24 September 2020

STATE SIGNIFICANT DEVELOPMENT APPLICATION (SSD8660), KARIONG SAND & SOIL SUPPLIES FACILITY, LOT: 4 DP: 227279 NO. 90 GINDURRA ROAD SOMERSBY

Thank you for the opportunity to provide comment on the amended Environmental Impact Statement (EIS) and Response to Submissions (RTS) for the above proposal. The following comments are made on the response to submission and proposal as amended.

## Concrete kerbing (no right turn on Debenham Rd)

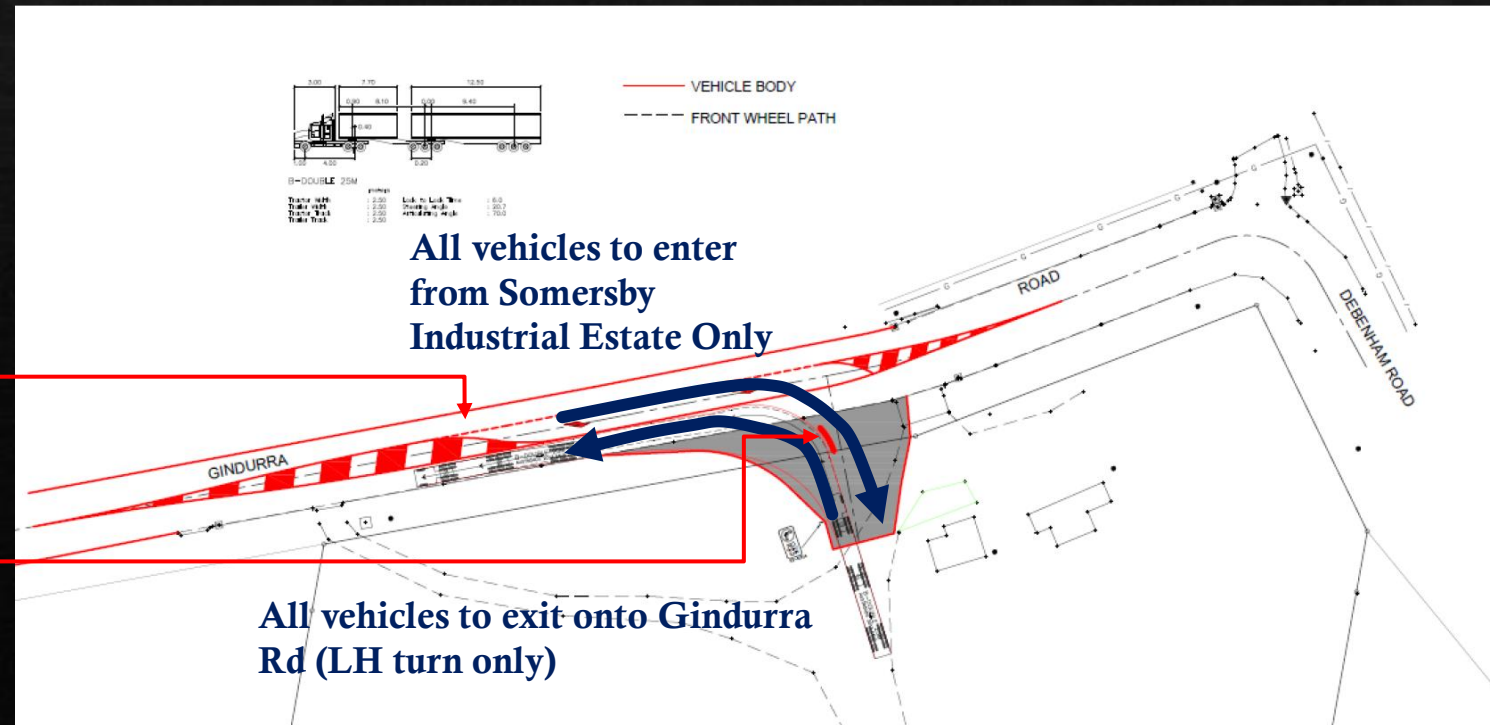
- On-street parking within Gindurra Road will no longer be available when the line marking associated with the channelised right turn bay into the development is implemented.
- Concrete kerbing proposed to deny right turn movements out of the site should not obstruct the footway.
- The plans for the development do not appear to set back the entry gates as per the recommendation of the TIA.

Figure 1. Barking Owl Targeted Survey November 2020 (Narla Environmental)

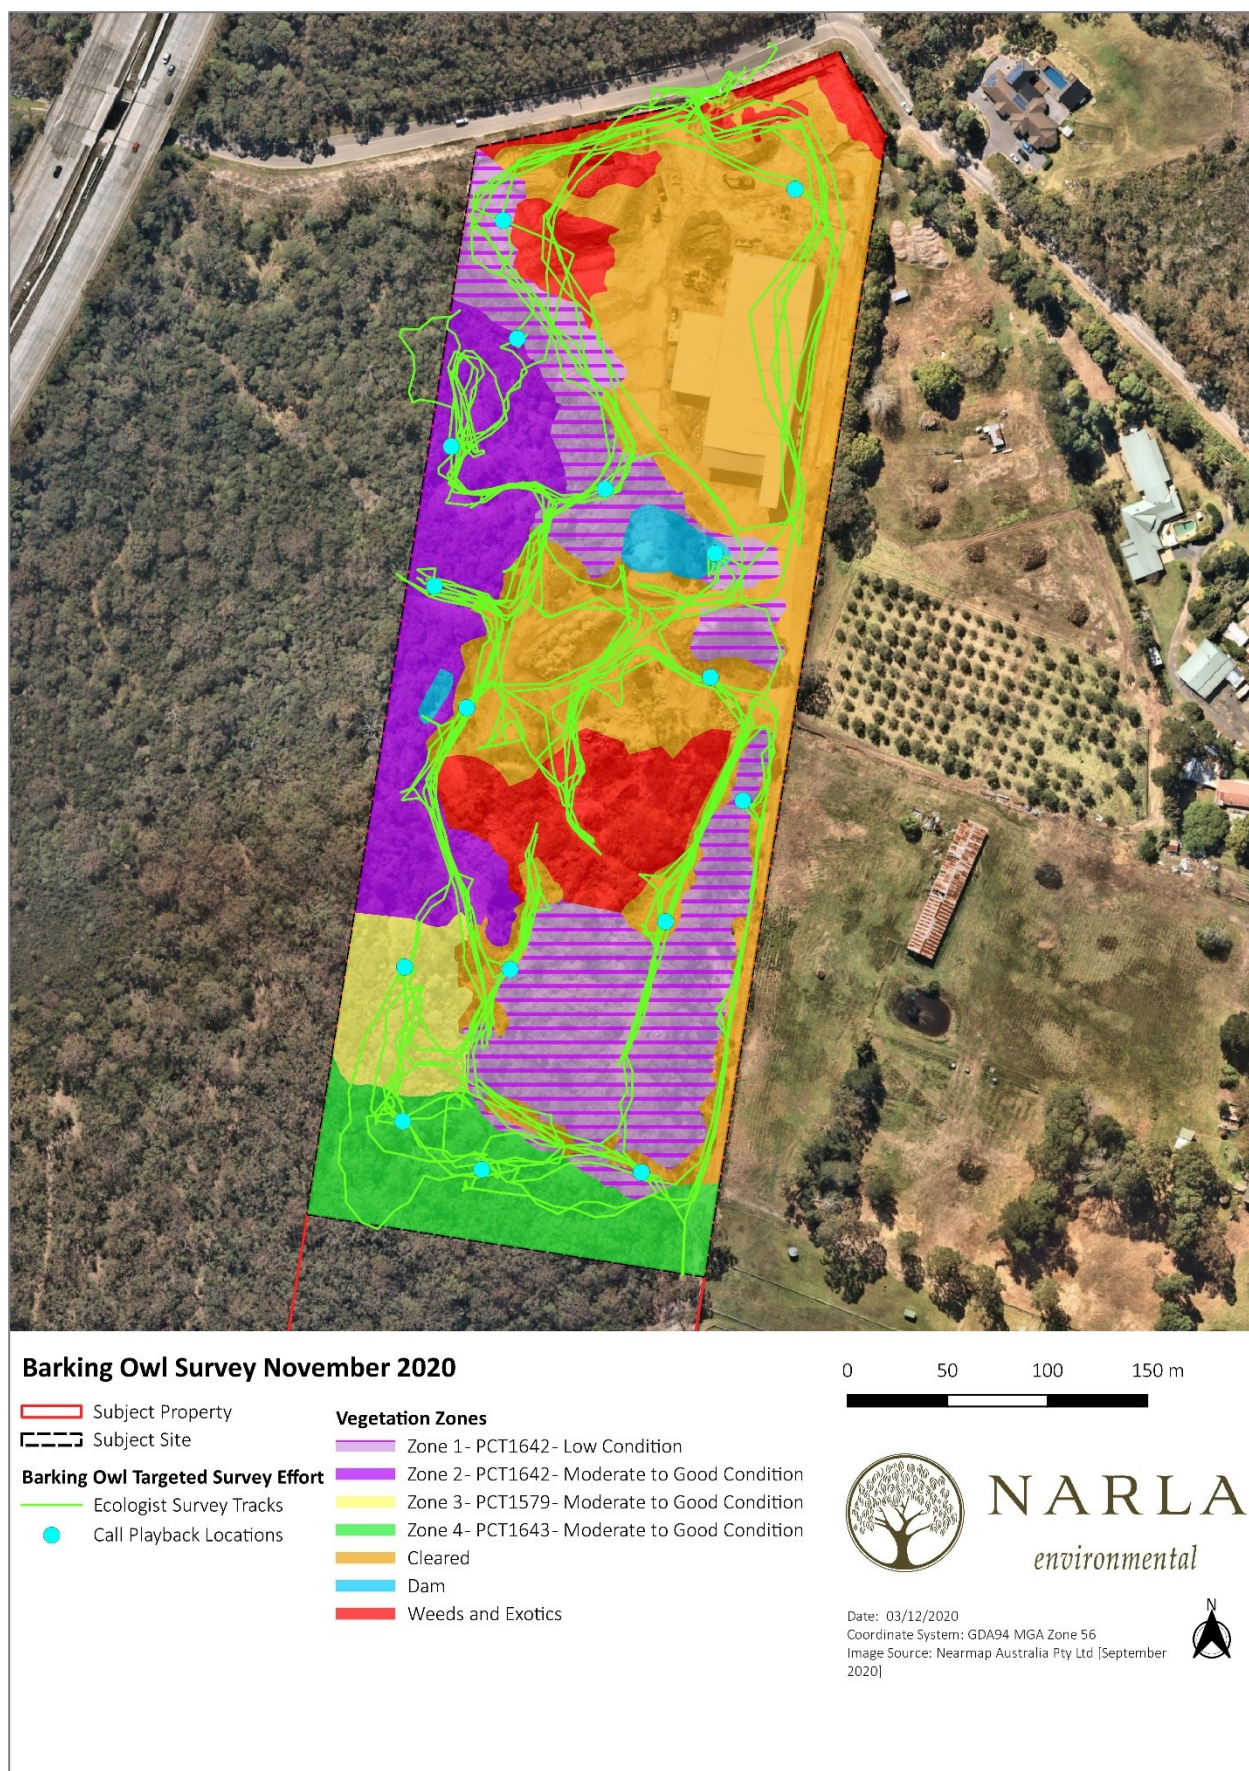
2. *Barking Owl Species Credits*: More assessment is required as to whether species credits for Barking Owl breeding habitat are required. The report details that the Barking Owl (*Ninox connivens*) was confirmed on site, but no further detail is given such as the type of sighting, timing of sighting(s) or location. This would need to include survey for nest trees within 100m of the development area in accordance with the requirements of the NSW Threatened Biodiversity Data Collection (TBDC).
3. *Prostanthera junonis species credits*: The purchase of *Prostanthera junonis* species credits is not included in the report. The 2020 DPIE "Surveying threatened plants and their habitats - NSW survey guide for the Biodiversity Assessment Method" includes the following recommendation on assuming presence of *Prostanthera junonis* on long undisturbed sites:

Figure 2. Hollow-bearing Trees mapped by Narla Environmental in November 2020

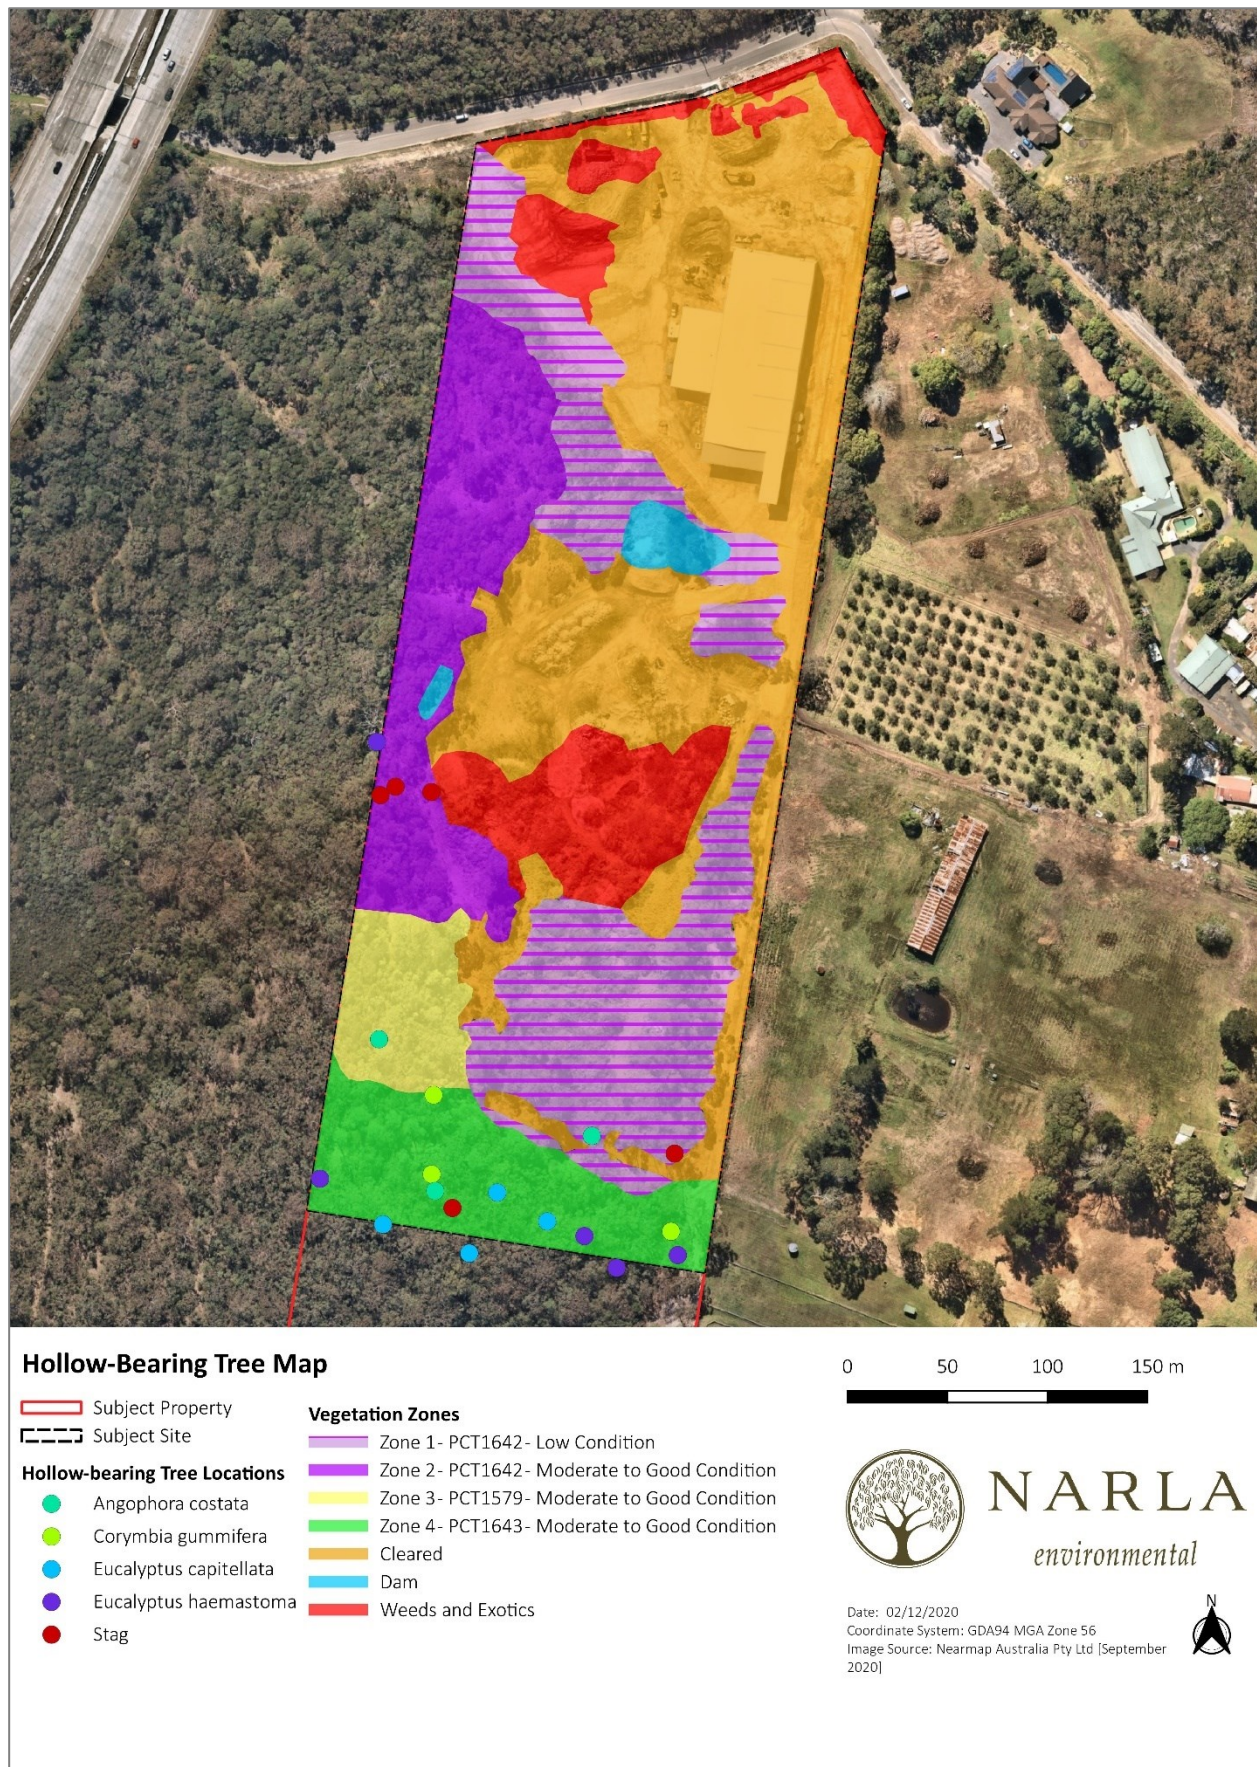
5. *Hollow Bearing Trees*: There is a lack of information about distribution of hollow bearing trees on the site. The largest number of hollows is reported from Plot 6 within Zone 4 in the southern part of the study area. As there is no overlay of the development area shown on the figures in the Biodiversity Assessment Report, it is difficult to determine whether there is scope to retain any of the vegetation containing hollow bearing trees in this area. Council would request the Biodiversity Assessment Report include hollow bearing tree mapping and an

overlay of the development footprint to better identify areas where hollow bearing trees would be retained.
